A47 Blofield to North Burlingham

Scheme Number: TR010040

Volume 8 **8.13 Statement of Common Ground** **with National Highways** **and Blofield Parish Council**

STATEMENT OF COMMON GROUND

GENERAL ARRANGEMENT PLANS  
REGULATION 5(2)(o)  
SHEET 7 OF 8

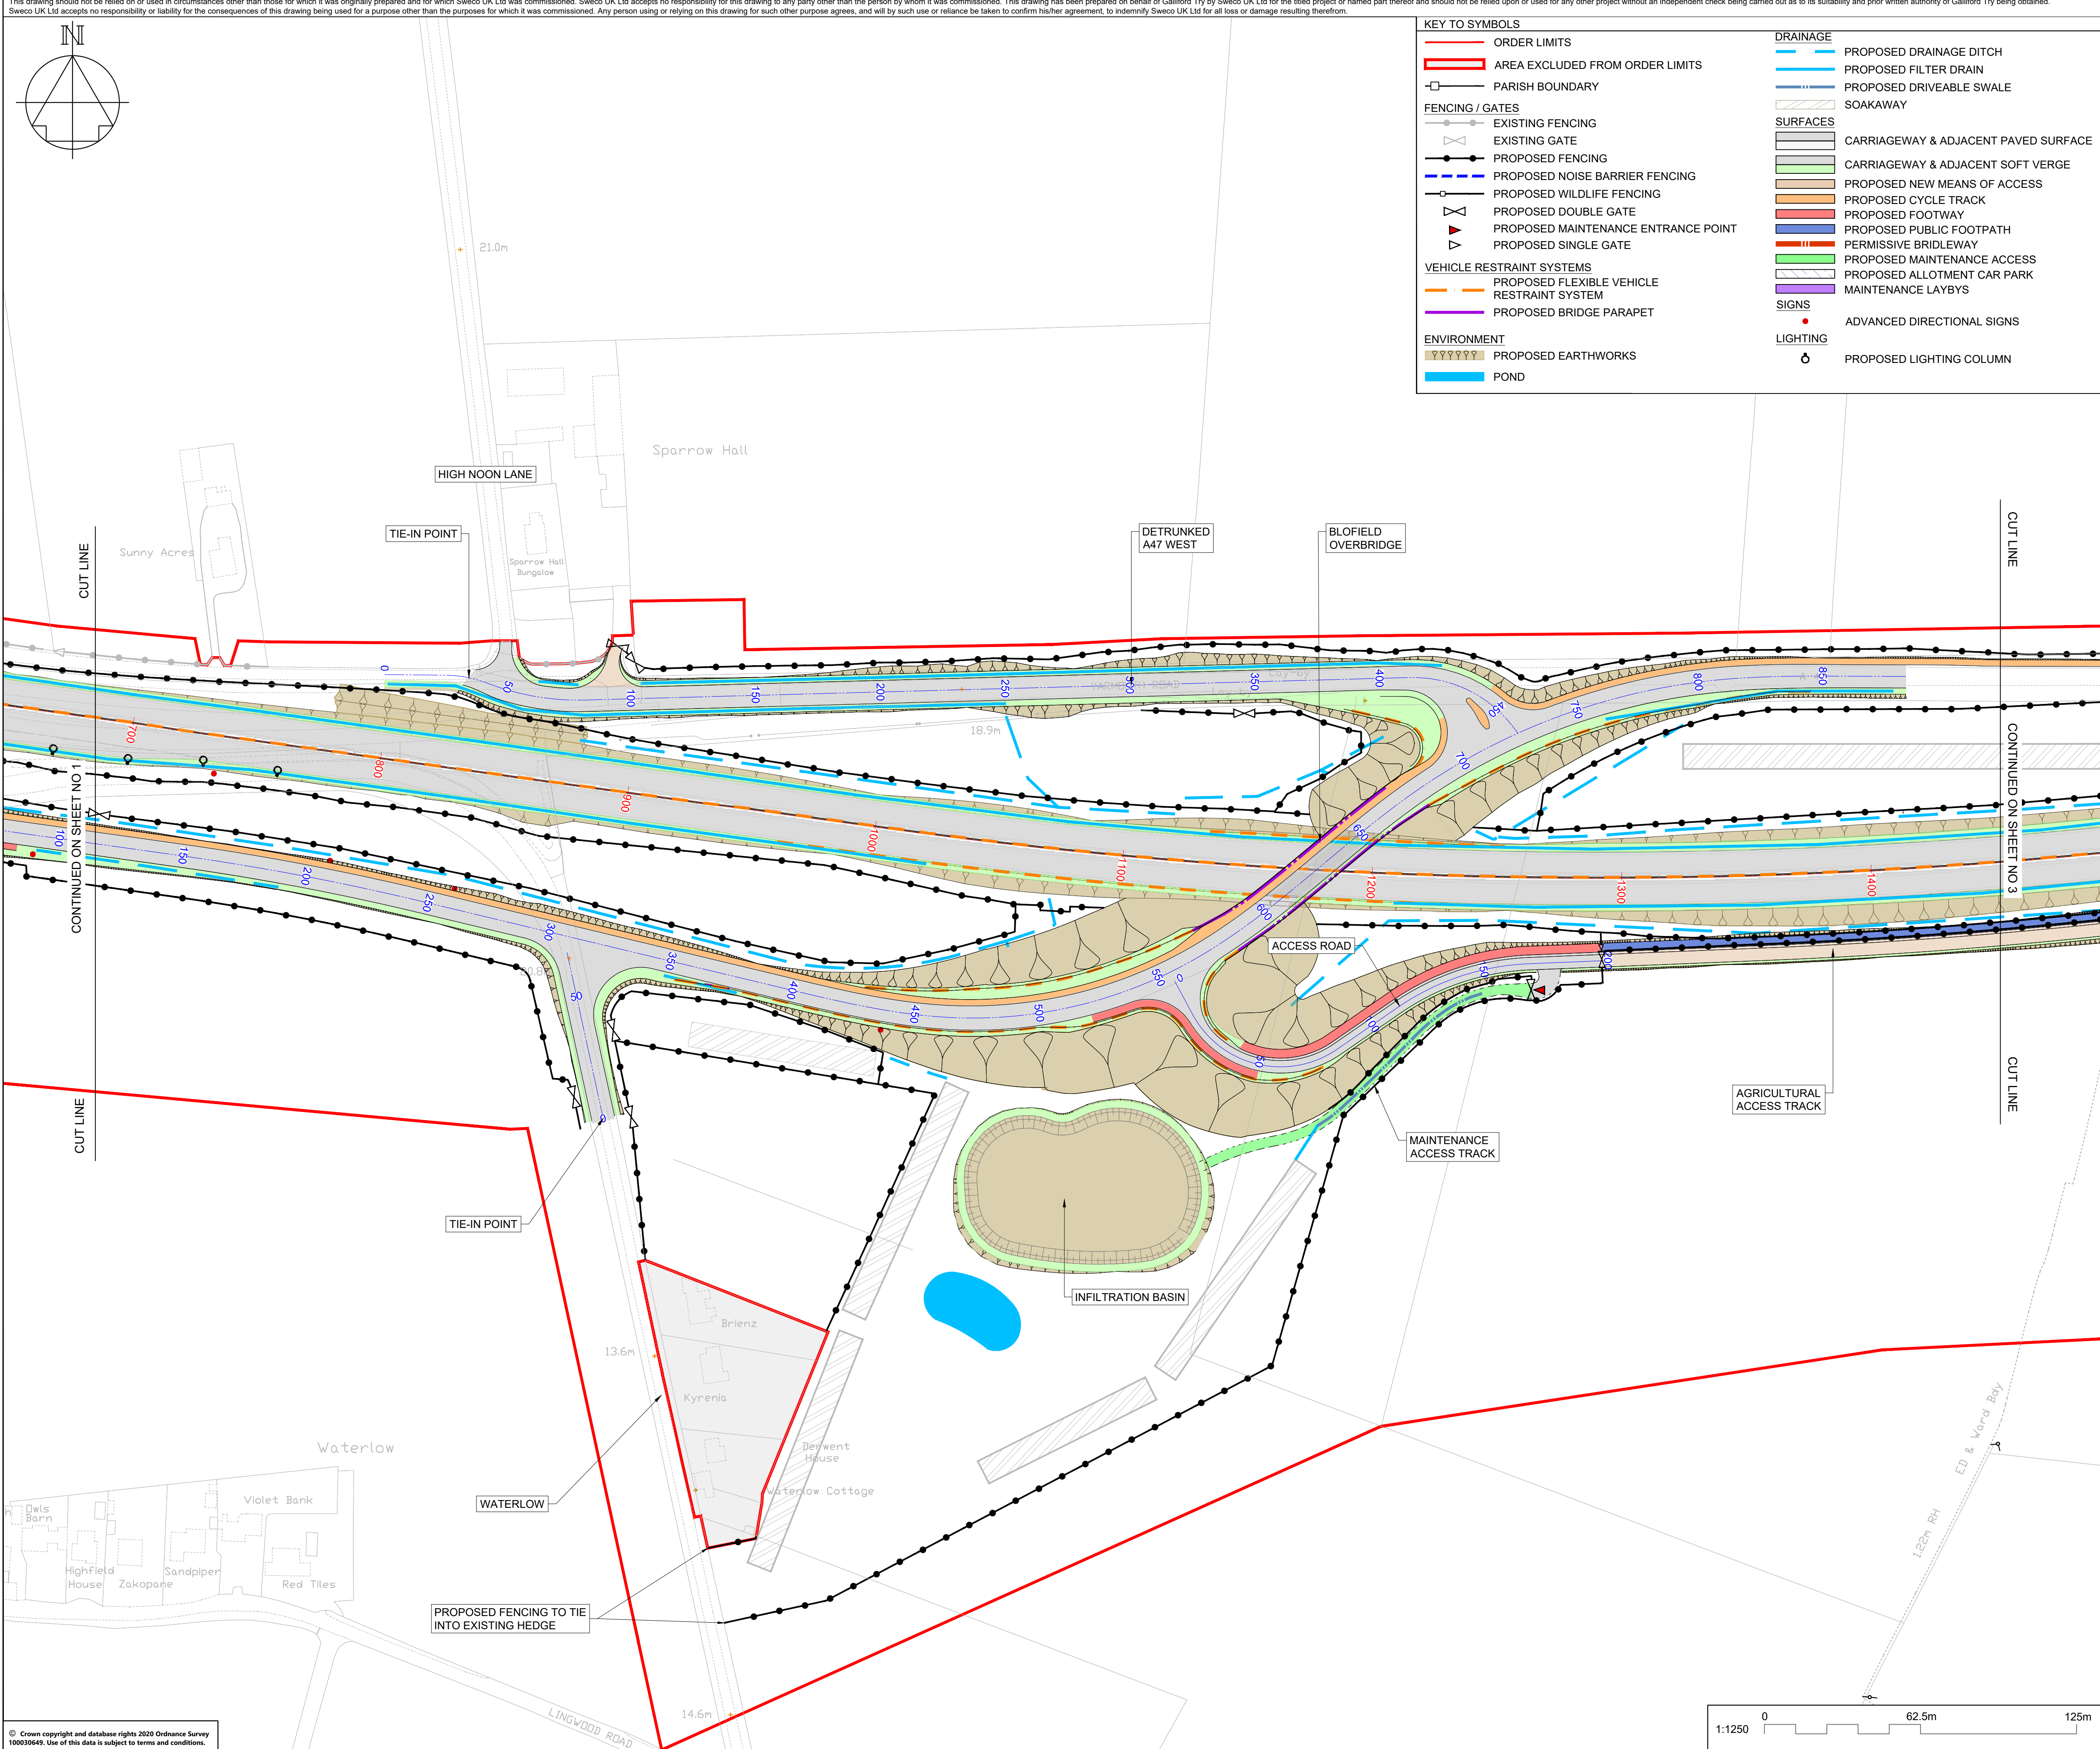
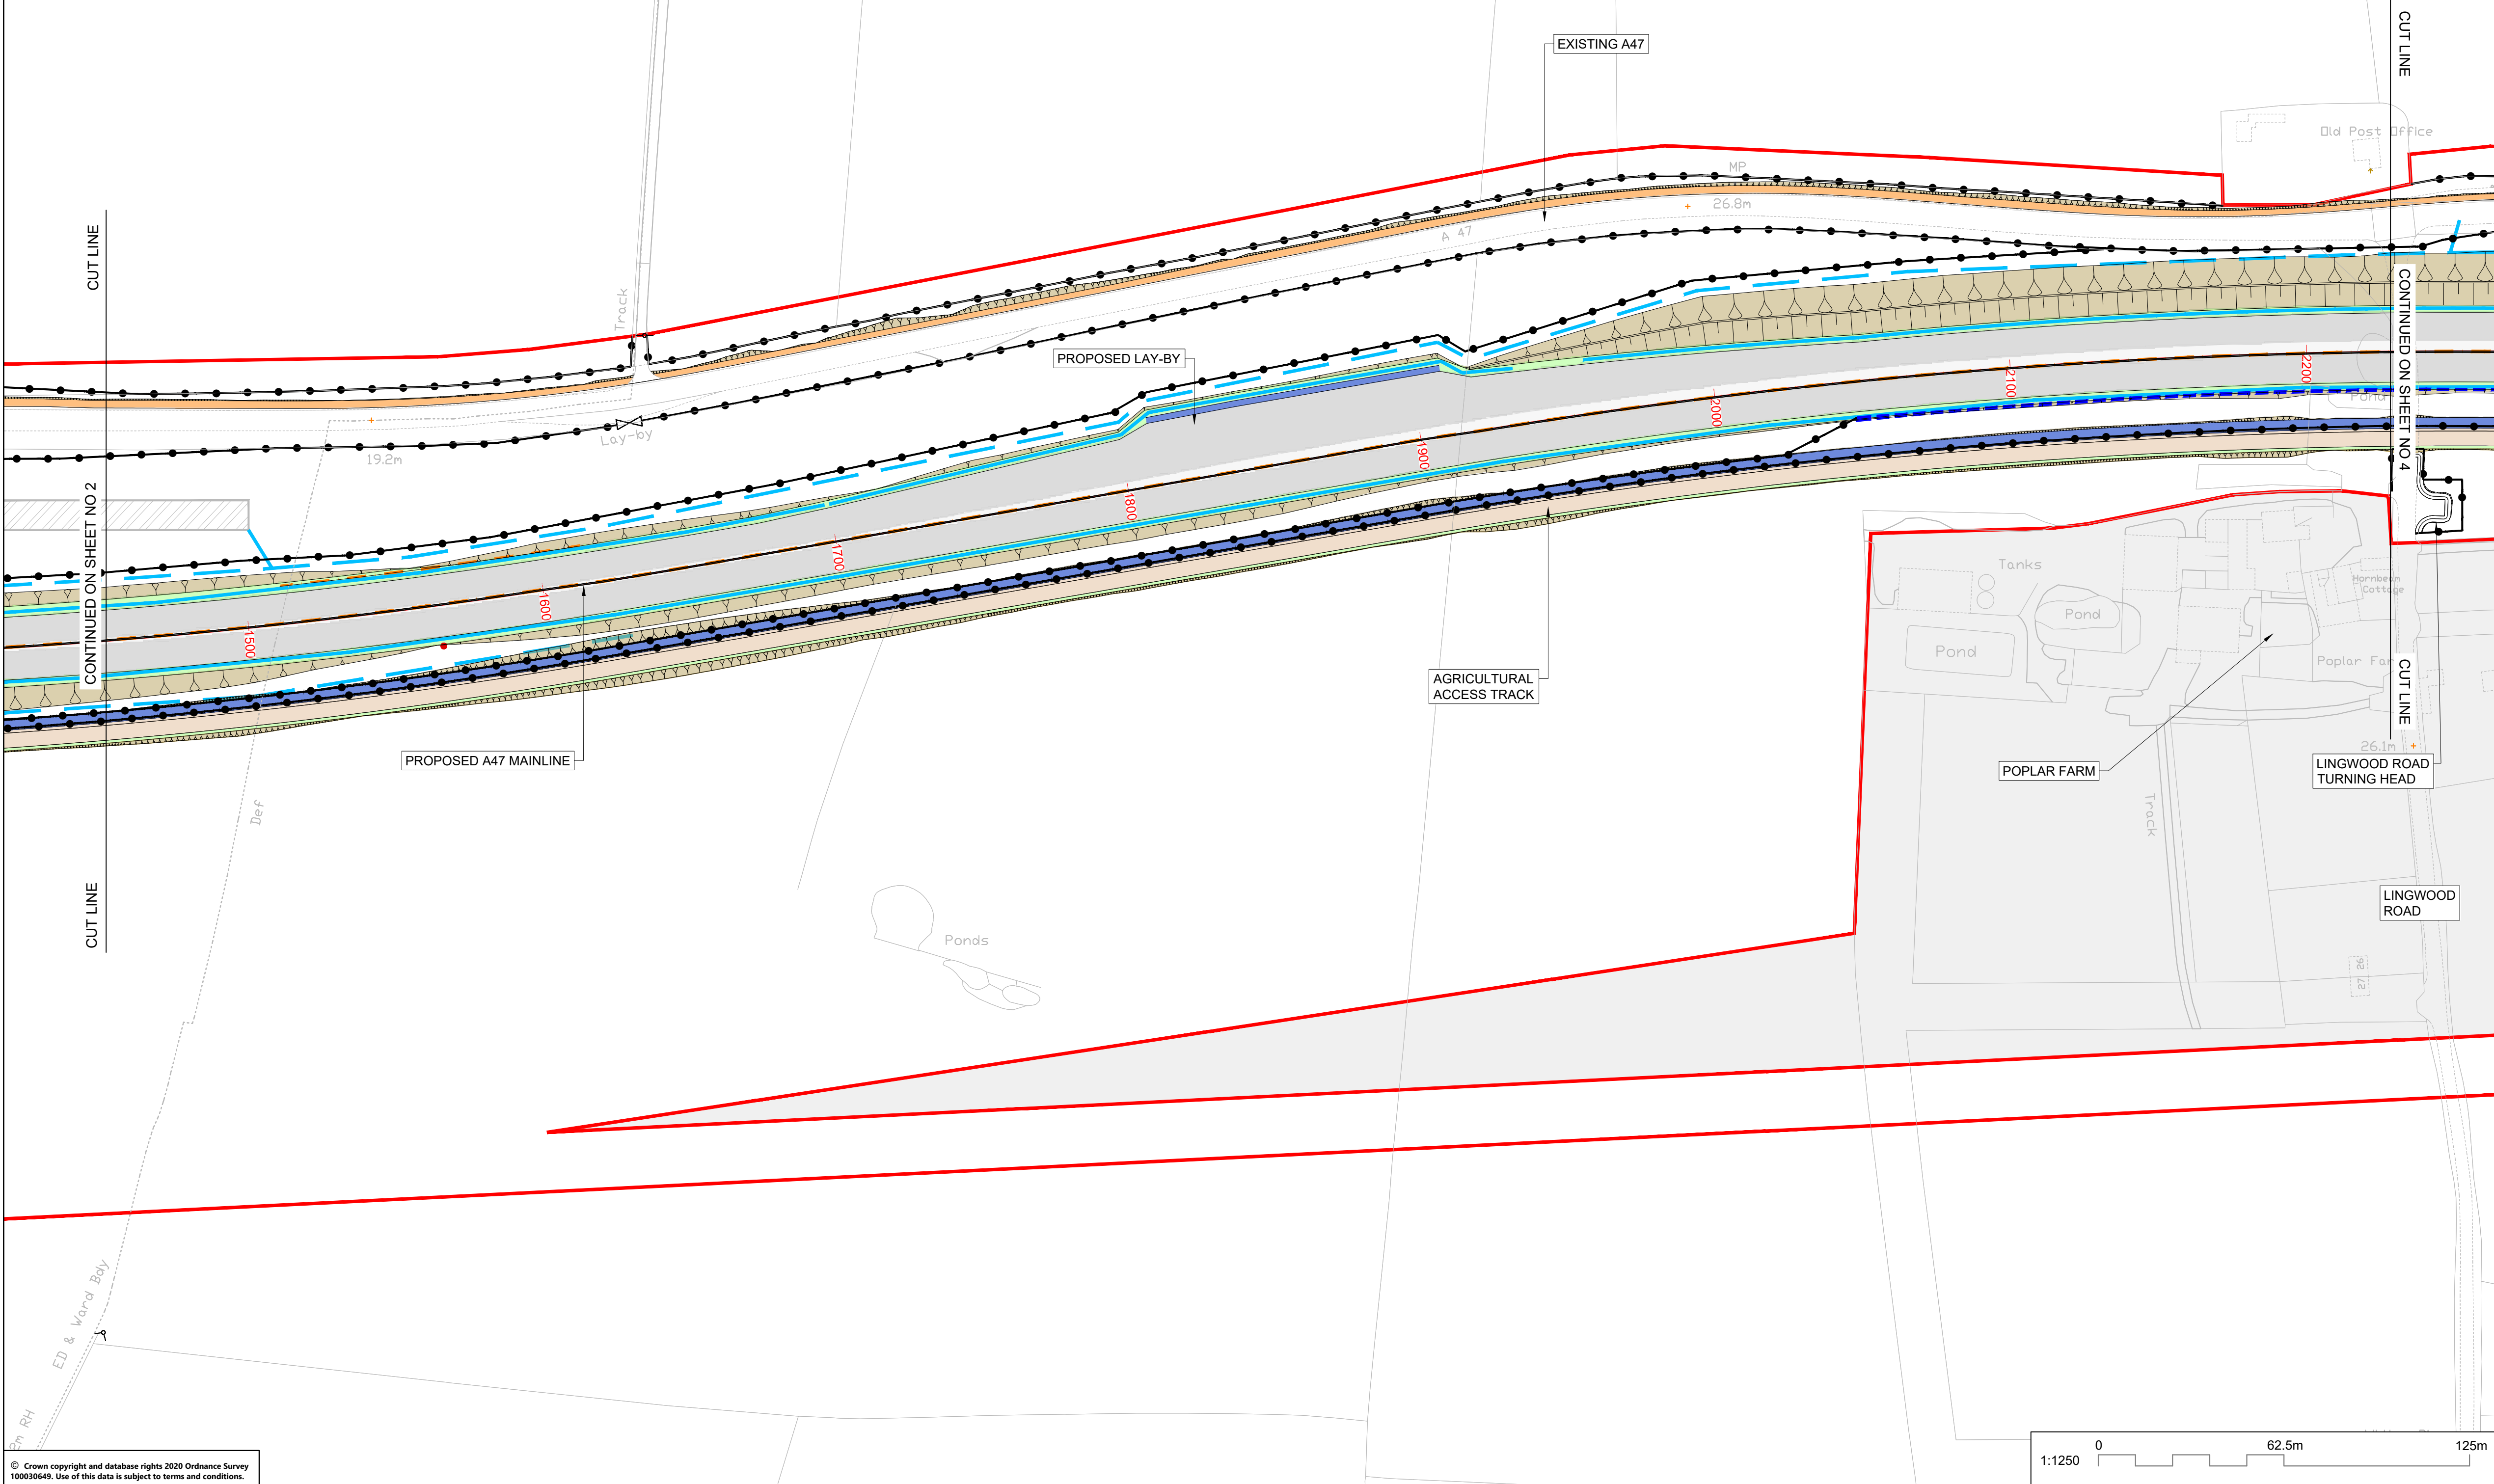
Issue	Document Reference	Blofield Parish Council Comment	Applicant's Response	Status	Date
Blofield Allotments – Water tank	Email from BPC in Appendix F	Unless a new water tank is being provided by HE, the existing one will need to be moved and operational within 48 hours if the move takes place between 1 April and 30 September, when the water supply is turned on and therefore in regular use. Outside these dates there is more flexibility.	See response above in relation to the water tank	Agreed	11-Nov-21
Blofield Allotments – Fencing	Letter from BPC in Appendix A & Letter from BPC in Appendix H	New rabbit proof fencing installed etc. and although these seem minor issues the plot holders are concerned.	The fencing design has been amended to reflect the concerns of the plot holders, as shown on the General Arrangement Plans (REP7-005).	Agreed	11-Nov-21
Blofield Allotments – Fencing	Letter from BPC in Appendix C	Will there be sufficient space to facilitate access to the two haulage ways on the main allotment plots?	The layout of the carpark and fencing has been amended to ensure access to the haulage ways on the main allotment plots, as shown on the General Arrangement Plans (REP7-005).	Agreed	11-Nov-21

Road Lighting	Letter from BPC in Appendix C, Appendix H & Appendix I	<p>2.6 General Arrangement Plans</p> <p>The proposed 20 lighting columns would be in contradiction of the Blofield Neighbourhood Plan Environment 5 Policy regarding Dark Skies. If the proposed junction was amended as per our suggestion at the beginning of this document, then the junction lighting would not be in contradiction to our local plan policy.</p>	<p>As described in the Scheme Design Report (REP1-046) lighting is proposed at the Yarmouth Road as road safety mitigation. The lighting will be LED and include back shields, where appropriate, to limit light spill.</p> <p>The modified junction arrangement as proposed by Blofield Parish Council is not a technically viable solution. Whilst Option B, considered in the Scheme Design Report (REP1-046) may not require lighting, it would have other environmental impacts resulting from the increased land take and additional construction.</p>	Agreed	20-Dec-21
